Northampton Gateway RFI: Comments on the draft Land Plans, Works Plans and the Rail Phasing Plan

These queries relate solely to matters raised by the drafting of the Plans and not the merits of the proposal. They are limited by the time available for consideration, and raised without prejudice to the acceptance or otherwise of the eventual application. They are provided to assist the preparation of the next iteration.

Drawing Title		WORKS PLANS KEY PLAN	
Scale	1:15,000	Drawn	P. Goodyear
Size	A1	Reviewed	S. Hilditch
Regulation	5(2) (j)	Document	2.2
Drawing Status		SUBMISSION	
Drawing No.		Revision	
NGW-BWB-LSI-XX-DR-C-00160		P12

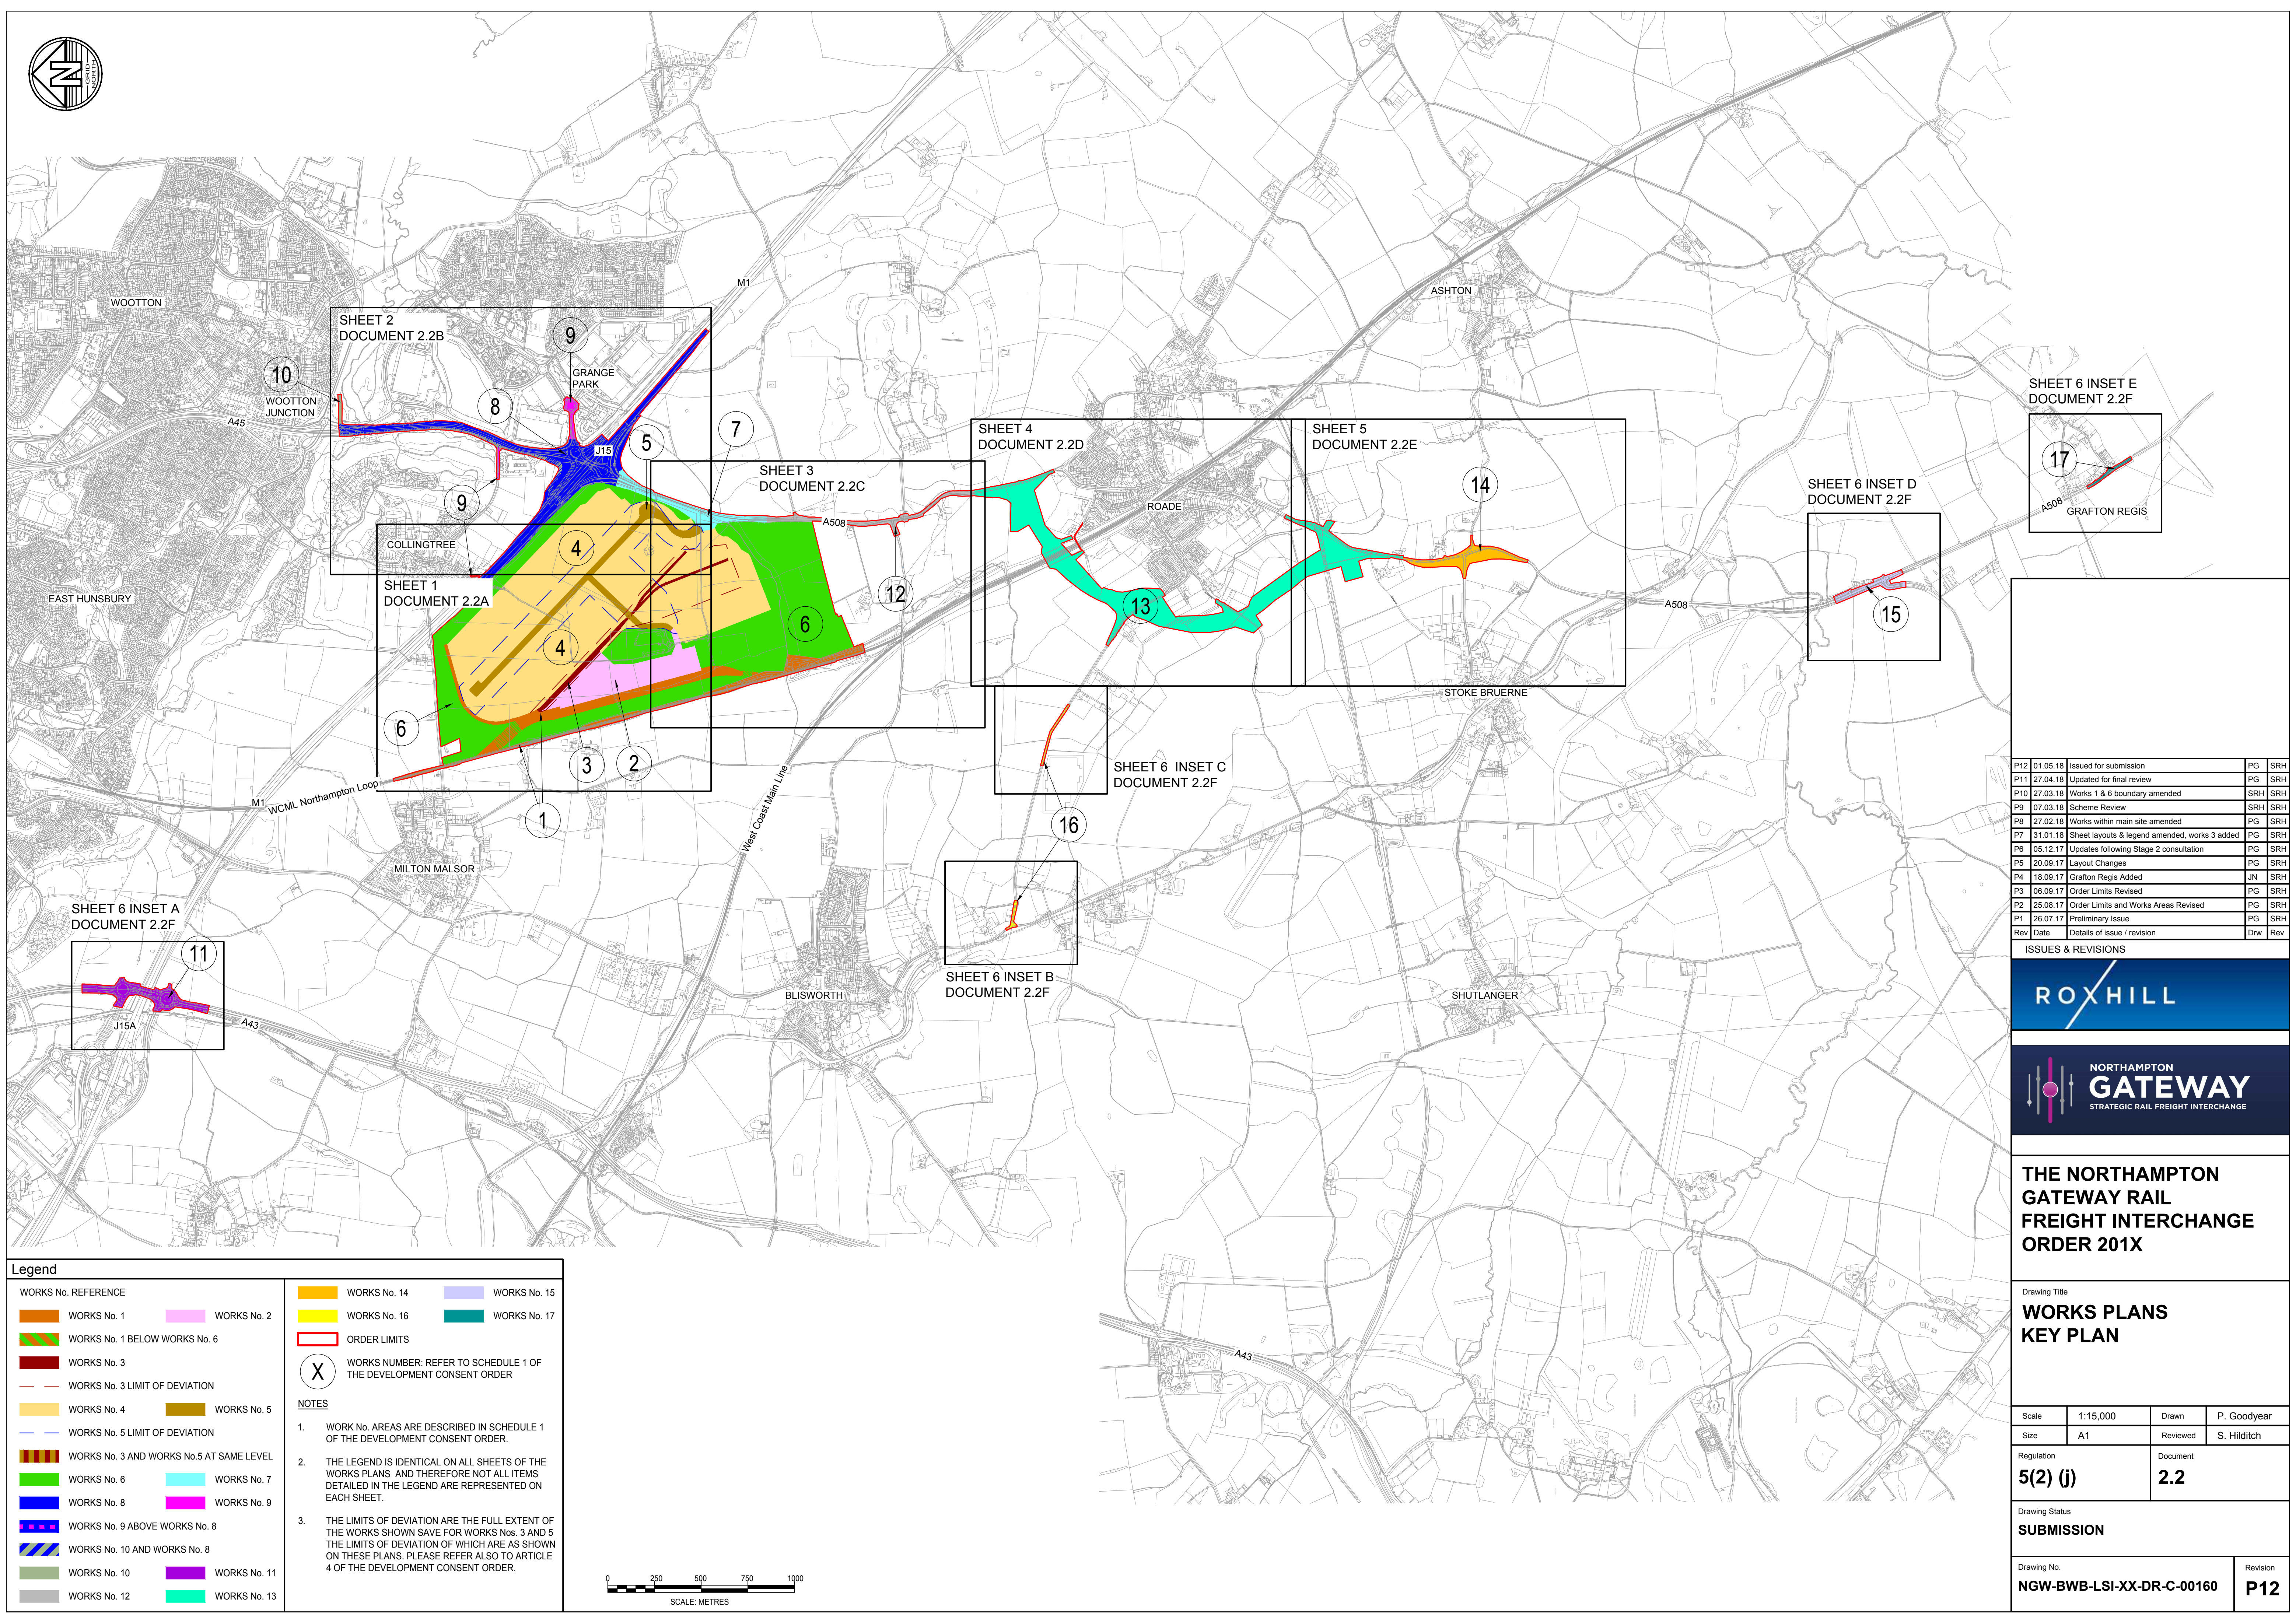
| Q No. | location | Description of issue | Question/Comment |
|--------------|-----------------|---|---|
| 1. | General | Limits of Deviation | <p>We note the Legend in relation to Limits of Deviation (LoD) including note 3 which states:</p> <p>“Any boundary between the areas of two Works numbers may deviate laterally by 20 metres either side of the boundary within the order limits”.</p> <p>If 20 metres is included in the LoD on the plan, is that 20 metres in total or 20m either side (40m). Are the LoD included in the works as drawn on the plan? If not, consider the interrelationships between the works. What is the effect of several works moving within these LoD?</p> |
| 2. | General | Lack of detail and size of proposed Works | <p>The detail of the proposed layout is not provided as a separate layer on the works plans. It would be helpful if the proposed layout was visible.</p> <p>Each separate work number could helpfully be broken down to give the reader a clearer understanding of the Works proposed especially in regards to phasing and understanding the individual aspects of each work.</p> |
| 3. | General | Unable to check Works against draft DCO | <p>It has not been possible to check the Woks Plans against the draft DCO as a revised draft has not been submitted. It is noted that several of the Works have changed.</p> <p>Please ensure all changes to the Works Plans have been reflected in the draft DCO and other relevant Application documentation.</p> |
